**KIRKLEES METROPOLITAN COUNCIL
INVESTMENT & REGENERATION SERVICE**

**DELEGATED DECISION FOR APPLICATION FOR CERTIFICATE OF
LAWFUL DEVELOPMENT**

Reference no.: 2024/CL/91755/E

Description: Certificate of lawfulness for proposed demolition of
existing conservatory and outbuilding and erection of single storey extension
to rear

Rear Elevation.
as Proposed

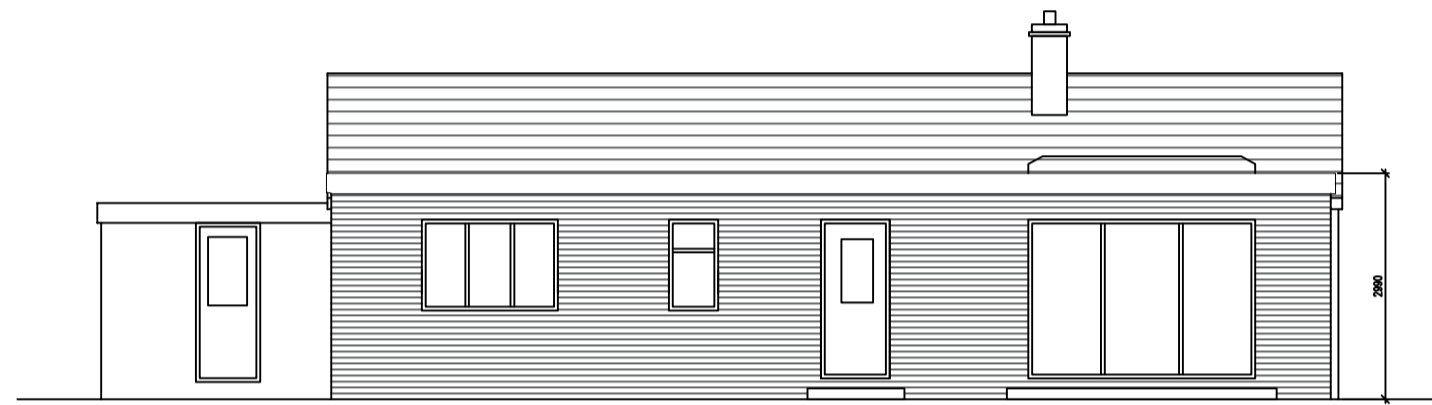
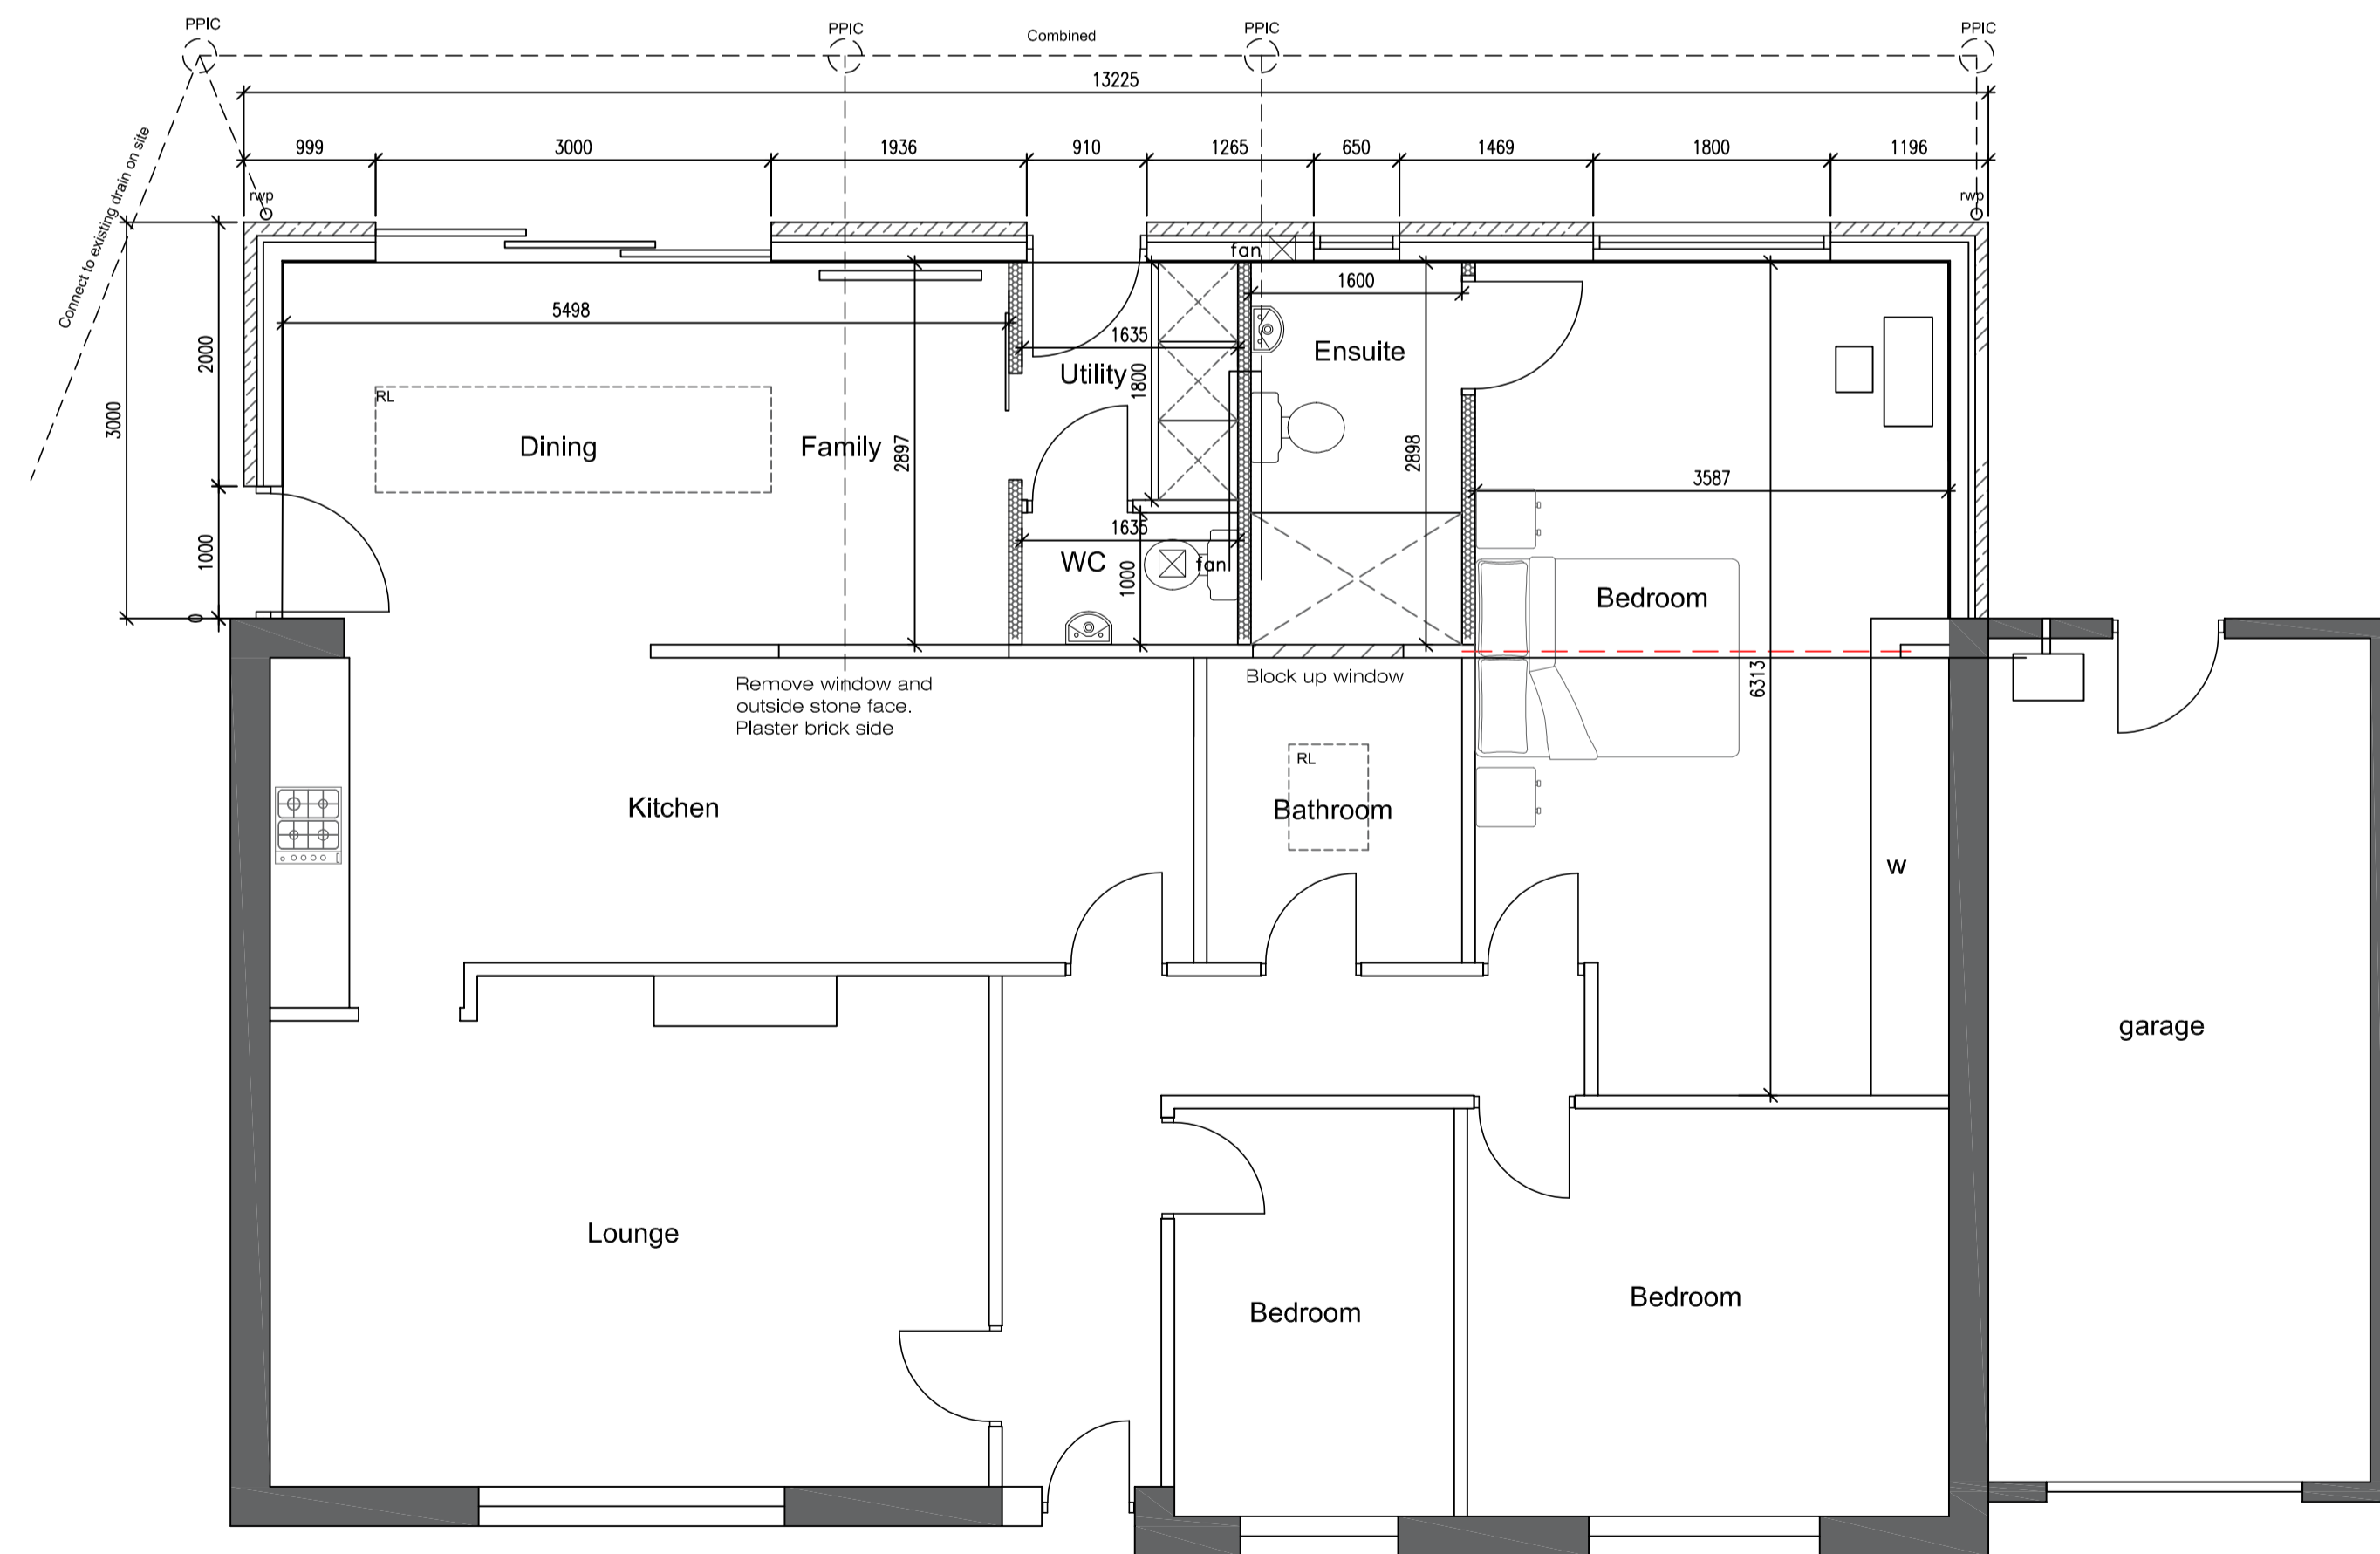
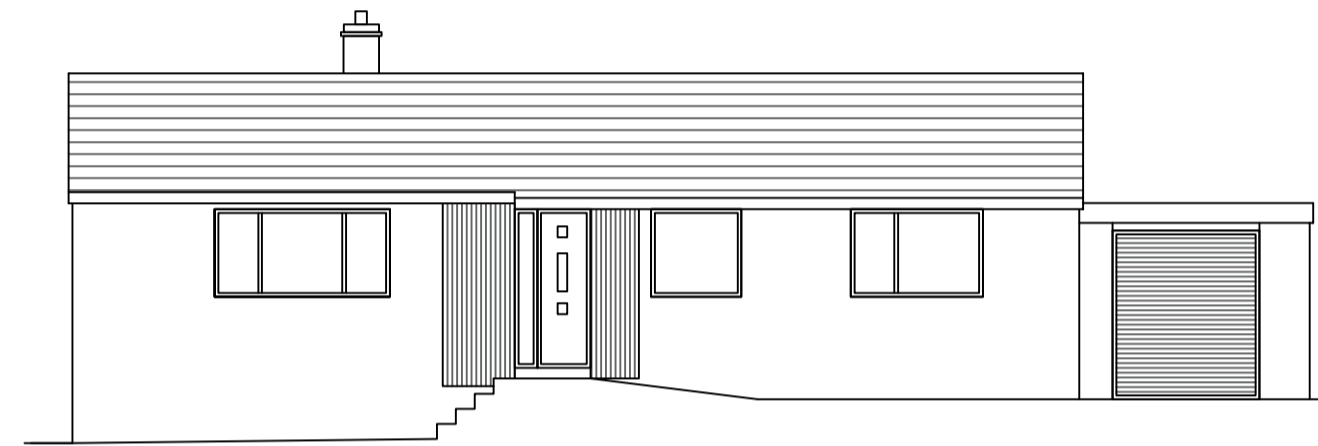
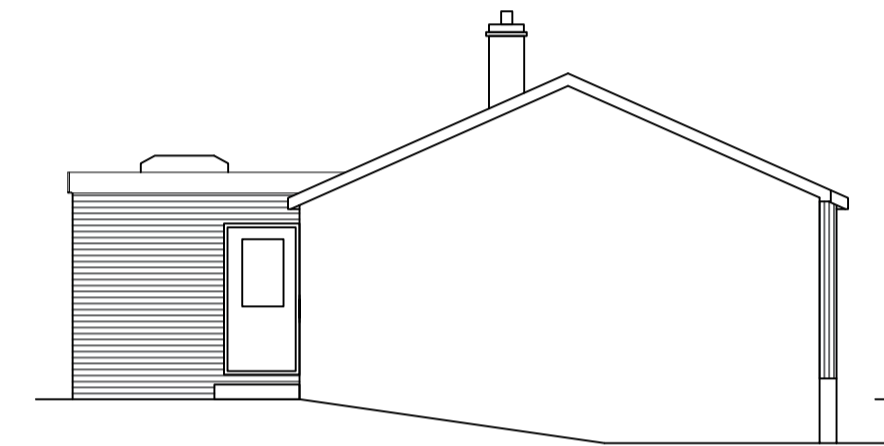
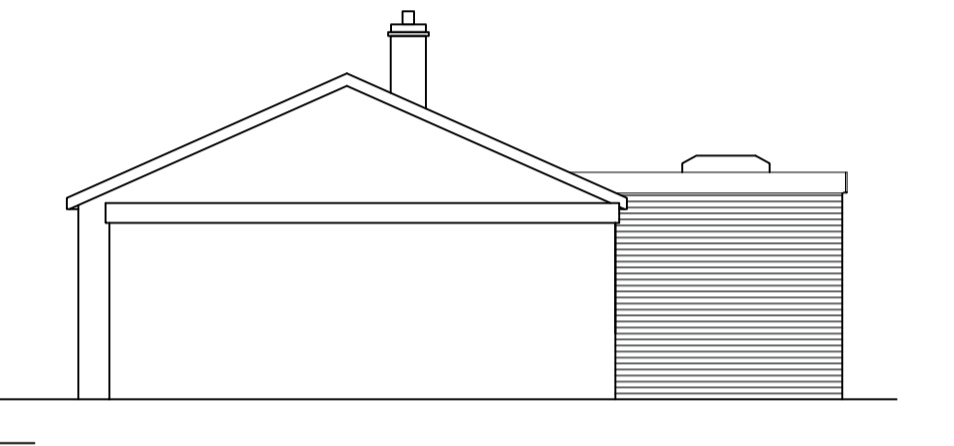
The extension would project from the rear elevation of the property by 3 metres and would be a total length of 13.2 metres. The proposed extension is to have a flat roof, with a total height (eaves and ridge) of 2.9 metres. There is also an addition of a roof light, protruding from the roof by 0.15 metres.

Comment: *The highest part of the extension would not exceed the height of the highest part of the roof of the existing dwellinghouse.*

Comment: *The height of the eaves would not exceed the height of the eaves of the existing dwellinghouse. The height of the eaves in this instance is considered to be below the soffit boards of the proposed enlargement.*

Comment: *The dwelling is a detached property and the extension would not project beyond the rear wall of the original dwellinghouse by more than 4 metres. It would not exceed 4 metres in height.*

Comment: *The extension is within 2 metres of the boundary of the curtilage of the dwellinghouse but the eaves of the enlarged part would not exceed 3 metres (2.9 metres proposed).*

Comment: *The extension would not project beyond a wall forming a side elevation of the original dwellinghouse.*

Comment: *The proposal would not adjoin an existing enlargement to the original dwellinghouse. The conservatory and outbuilding (porch) will be removed to facilitate the addition of the rear extension.*

Comment: *The proposed works include the addition of a roof light (an alteration to the roof) – this is assessed under Schedule 2, Part 1, Class C of the Town and Country Planning (General Permitted Development) (England) Order 2015 (as amended).*
